Planning Application Ref: BE/109/19/OUT

Location: Land east of Shripney Road & south of Haddan House, Shripney Road, Bersted, PO22 9NW

Description of works: Outline application with some matters reserved for up to 46No. dwellings together with access. This application is a Departure from the Development Plan & may affect the character & appearance of the Shripney Conservation Area

Mark Warwick
Tree Officer / Parks and Greenspace Team

DRAWING TITLE:
Preliminary Illustrative Layout

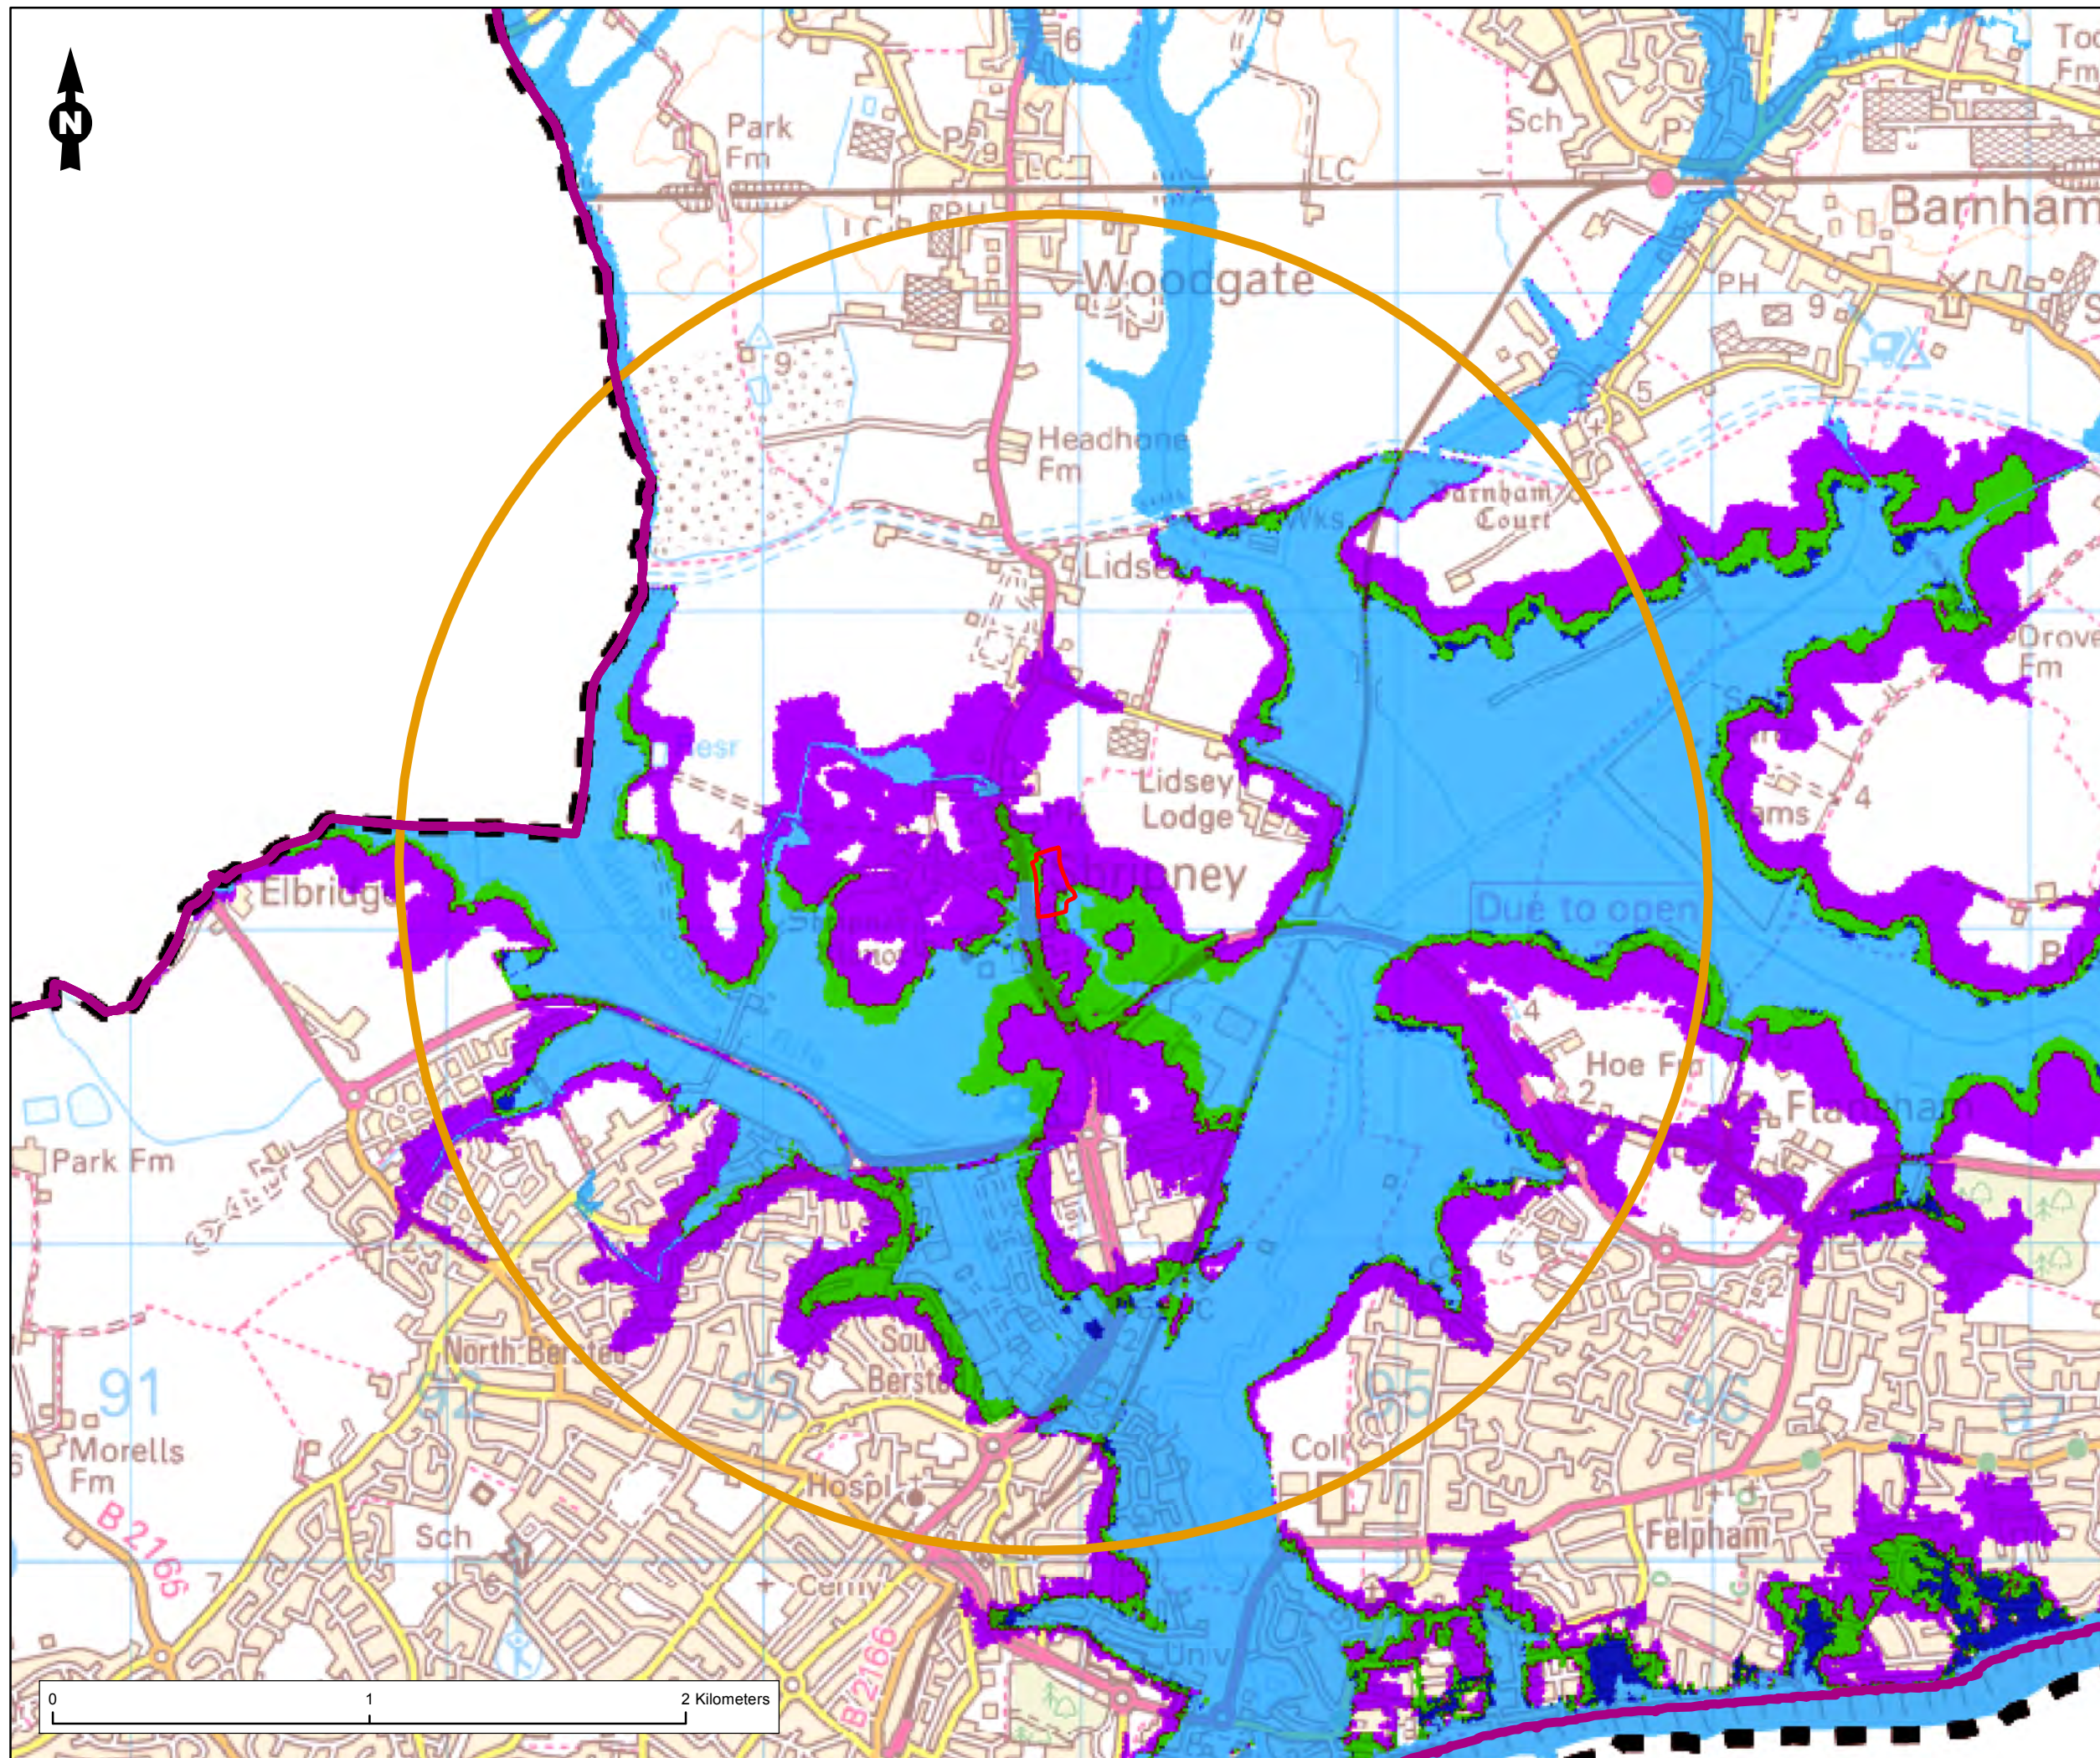
- I am concerned that the position or size/orientation of plots 6, 7, 31-33 incl., and 46 have high potential to impact on the health and vitality of TPO oak trees, arising from RPA incursion and future residential pressure to prune. I would like to see consideration given to enhancing and ensuring continuity of 'green corridor' along the entire eastern boundary.
- The location of the LEAP is unsatisfactory. Any proposal to install equipped play areas within and about the crown spread of large old trees is ill-advised from a safety perspective as well as increasing the likelihood of hazard abatement pruning which often leads to a diminution of those tree's landscape and ecological value.
- An alternative to the proposed footway between 33 and 34 should be found, so as to avoid costly/disruptive incursion into the RPA of a TPO oak.
